## Ribble Valley Borough Council

**DELEGATED ITEM FILE REPORT - REFUSAL**

<b>Application No:</b>	3/2014/0124/P
<b>Development Proposed:</b>	Proposed two storey side extension, rear conservatory and two roof lights at 5 The Crescent, Dunsop Bridge, Clitheroe BB7 3BA

Project: Proposed Extension at 5 The Crescent, Dunsop Bridge. For Mr and Mrs Hughes.		Ron Valovin, Architectural Services, 9 Green Drive, Clitheroe, Lancs. BB7 2BB. Tel. 01200 427167.	
Title: PROPOSED PLANS AND ELEVATIONS.			
Scale: 1 to 50	Date: 10/12/13	Drawn: JAV	File Name: 390-2

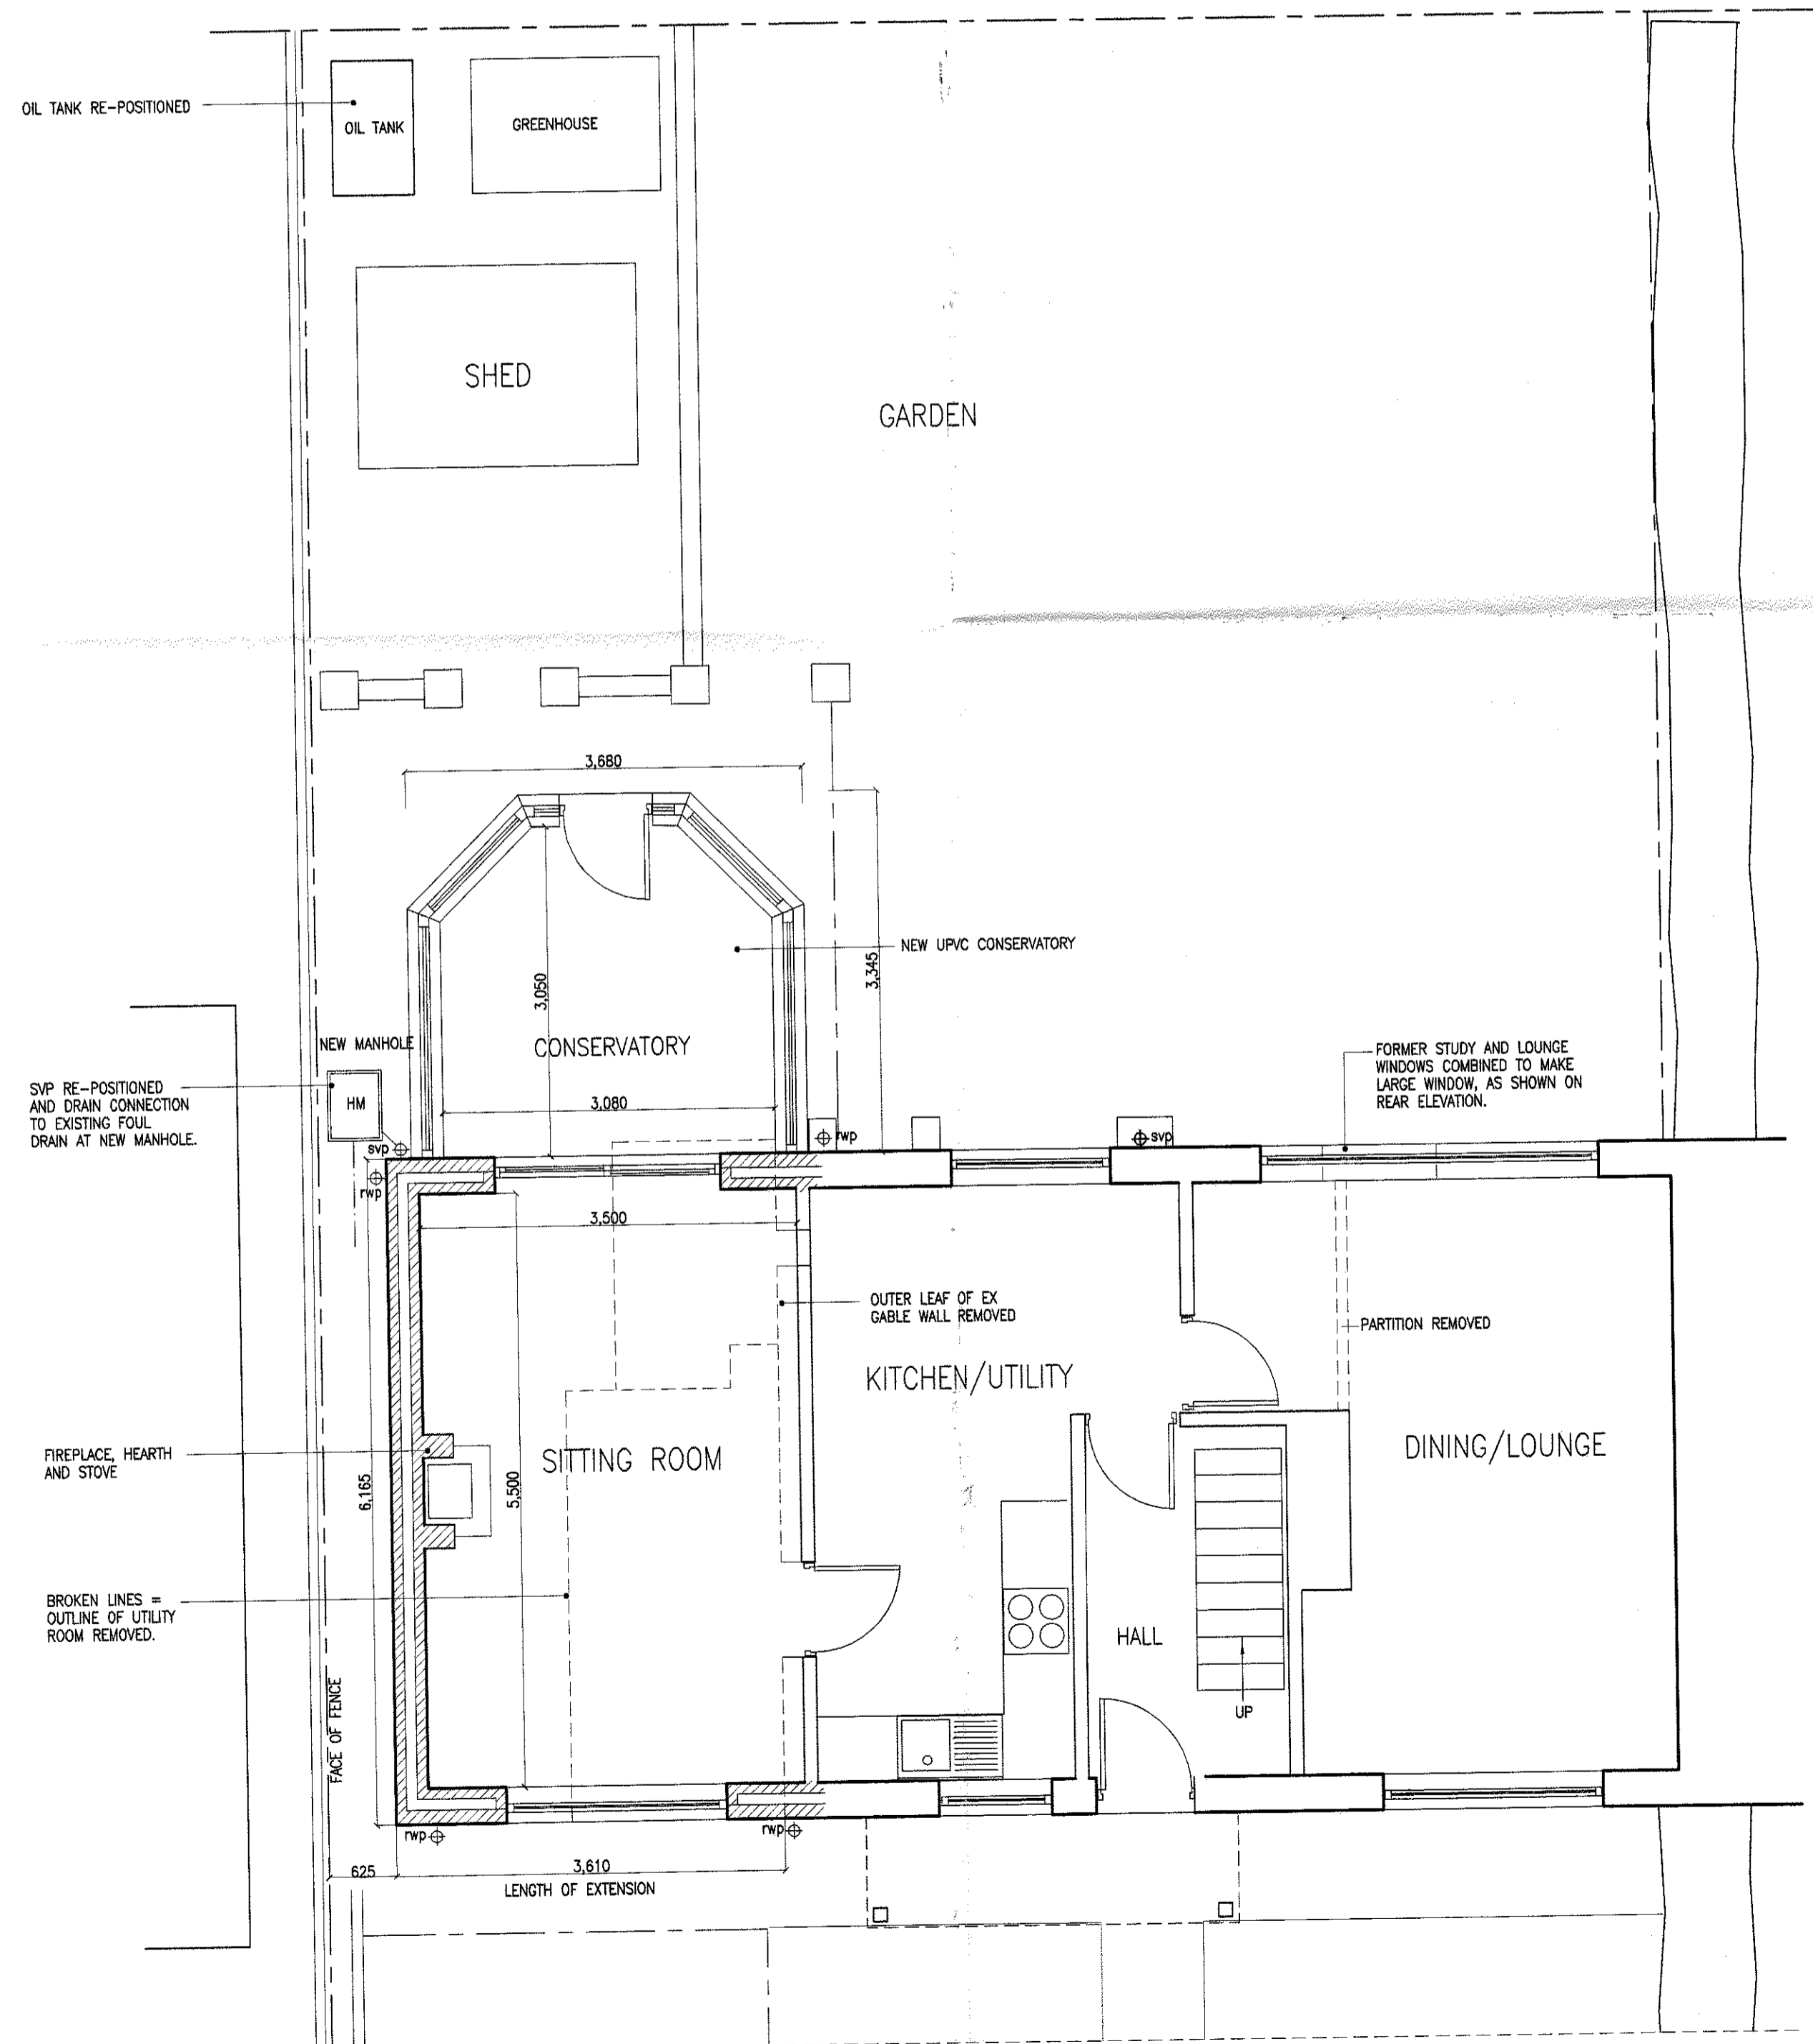
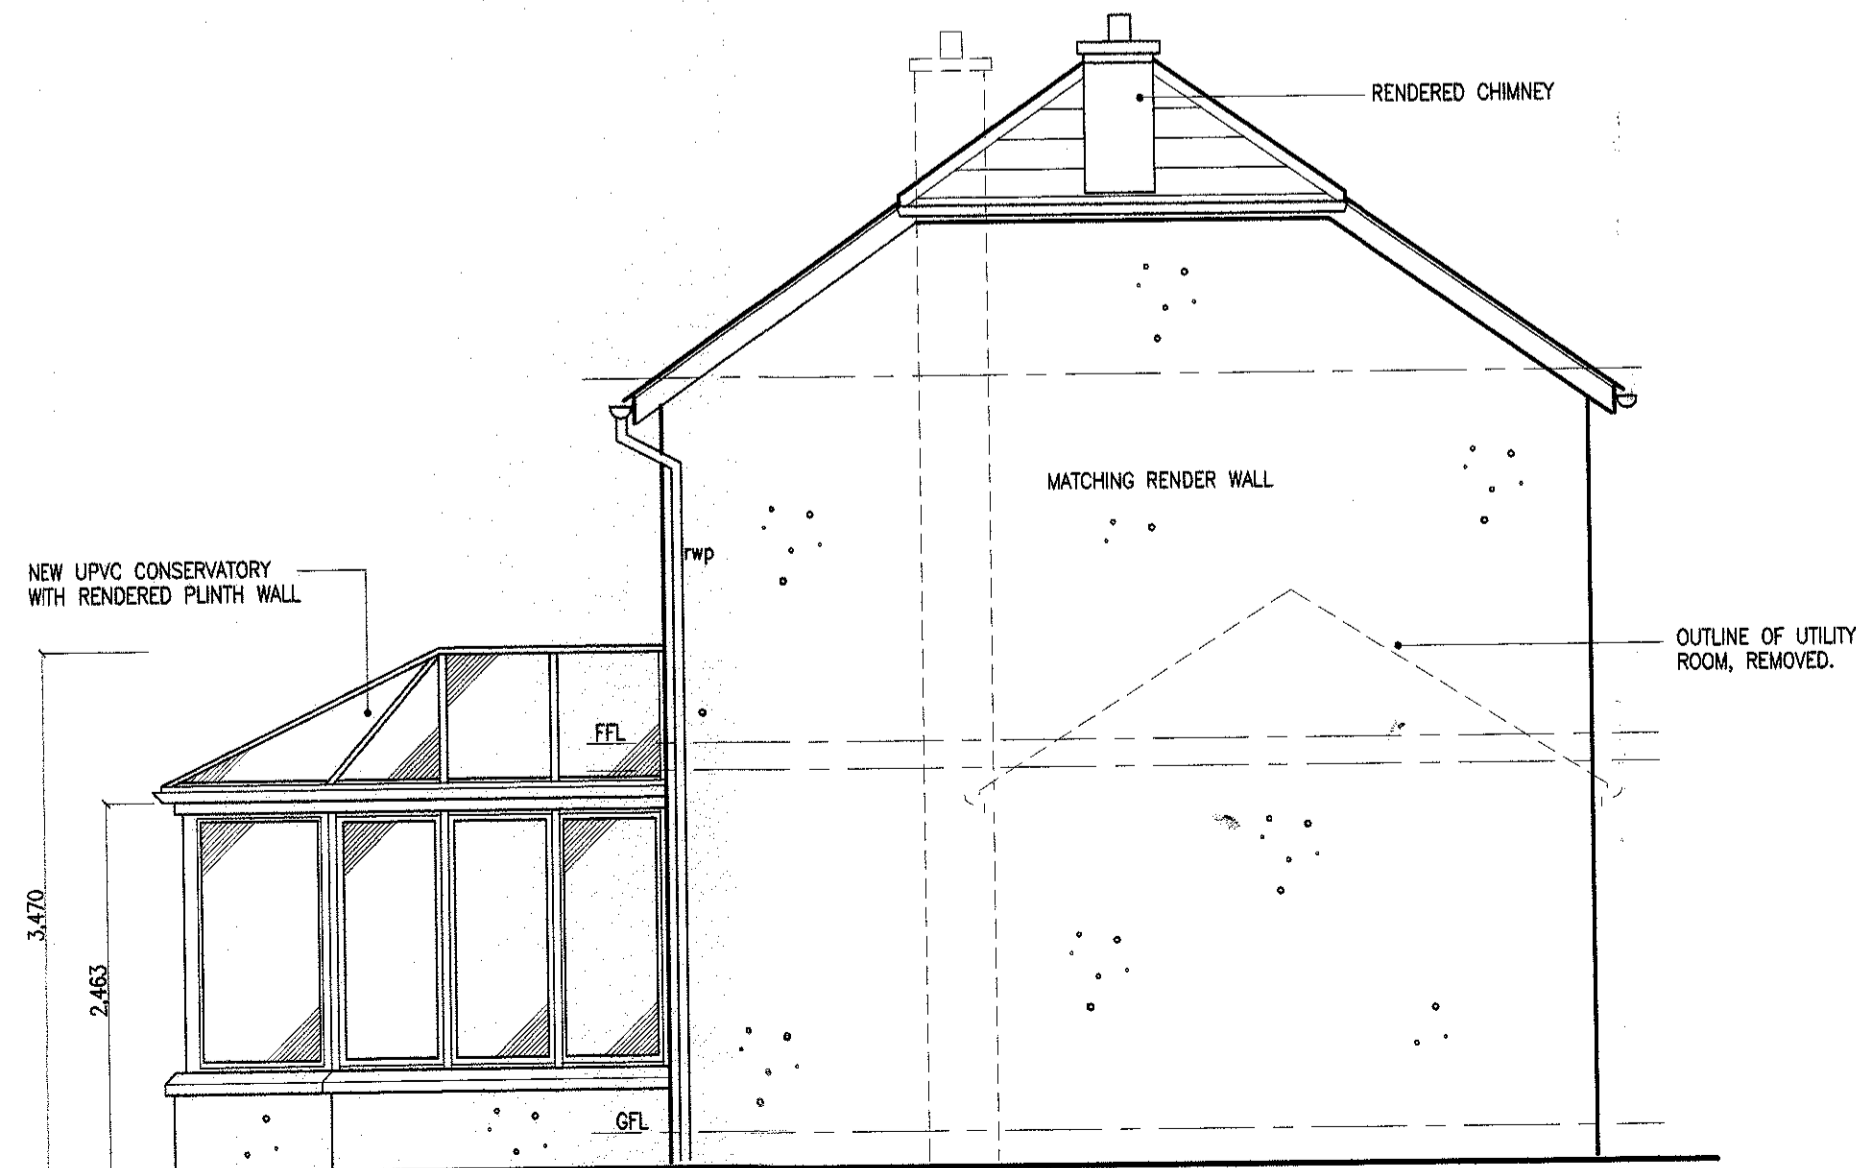
G1, ENV1, ENV3, H10, SPG, DMG1, EN2, DMH5 – terracing, detrimental to visual amenity and overlooking of neighbouring property.

The proposed extension would be built flush with the front and rear elevations and would follow the existing eaves and ridge heights of the dwelling. The two storey side extension would be built in from the shared boundary with No 4 The Crescent by only 600mm and the separation distance between No 4 and the application property would be reduced from 5.15m to 0.85m. In addition, the pair of semi-detached dwellings to which the property forms one part is parallel with the adjacent pair of semi detached dwellings on The Crescent and given no.4 has extended up to the shared boundary, I consider that doing similar with this property would result in a cramped form of development leading to a terracing effect in the street scene as the gap between the two pairs of semi-detached would be significantly reduced. In addition views of the countryside both ways would be significantly blocked to the detriment of visual amenity.

The resultant terracing effect would create a significant change to the basic character and layout of the original estate to the detriment of visual amenity, contrary to Policy G1 of the saved Local Plan and the Council's SPG on Extensions and Alterations to Dwellings. Furthermore, it would significantly detract from the visual amenities of the countryside in which the dwellings are set and the rural setting of the properties on The Crescent to the detriment of the wider visual amenities of this part of the Area of Outstanding Natural Beauty, in conflict with Local Plan Policy G1, ENV1 and ENV3, and also paragraph 115 of the NPPF, which requires Local Planning Authorities to give *great weight to conserving landscape and scenic beauty* in Areas of Outstanding Natural Beauty. As a result, I recommend the

The proposed conservatory at the rear of the property in the Crescent would be partially visible from the Trough Road and from the grounds of the village hall situated on the same road, however, I consider existing field hedging will screen the majority of the conservatory with only the upper portions of the conservatory being visible. I therefore consider this aspect of the proposal to be acceptable from a visual amenity perspective.

With regards to the proposed roof lights, only one other property has a roof light, No 4. When viewing the rear of the property from the Trough Road and grounds of the village hall, the reflectiveness of the rear roof light on No 4 appears as a stark contrast to the dull tiled roofs present on the semi detached properties and would be visually awkward. Similarly, solar panels exist on the rear of No 6 The Crescent that have a similar effect on the visual amenities of the AONB. The addition of a single roof light would add to the clutter on the rear roof slopes of the 14 properties to the detriment of visual amenity. The proposed roof light on the front roof slope would be the first one on the front elevation and would set a precedent for others to follow and similarly I also have concerns about the visual impact on the AONB, contrary to Policy ENV1 of the Local Plan.

In terms of the impact on neighbours, no windows exist on the gable of the side extension at No 4 adjacent, therefore no amenity issues will occur as a result of the two storey side extension. However, the rear conservatory would be fully glazed and this would lead to overlooking of adjacent properties garden areas. The SPG on Extensions and Alterations to Dwellings states:

No 4 The Crescent has a shed along the shared boundary of the two properties, therefore this will prevent any overlooking of this neighbour occurring. In contrast, an open view of the rear garden area of the adjoining property, No 6, would occur and I consider this would lead to unacceptable overlooking of the neighbour’s rear garden contrary to Policy G1 of the Ribble Valley Districtwide Local Plan and the Council’s SPG on Extensions and Alterations to Dwellings. In the interests of safeguarding the amenities of the existing and any future occupiers, I thus recommend the application also be refused on this basis.

To conclude, the proposals would lead to a terracing effect that would have a harmful effect on the visual amenities of the AONB. The rear conservatory would also harm the amenities of adjoining neighbours, and I therefore recommend the application be resisted.
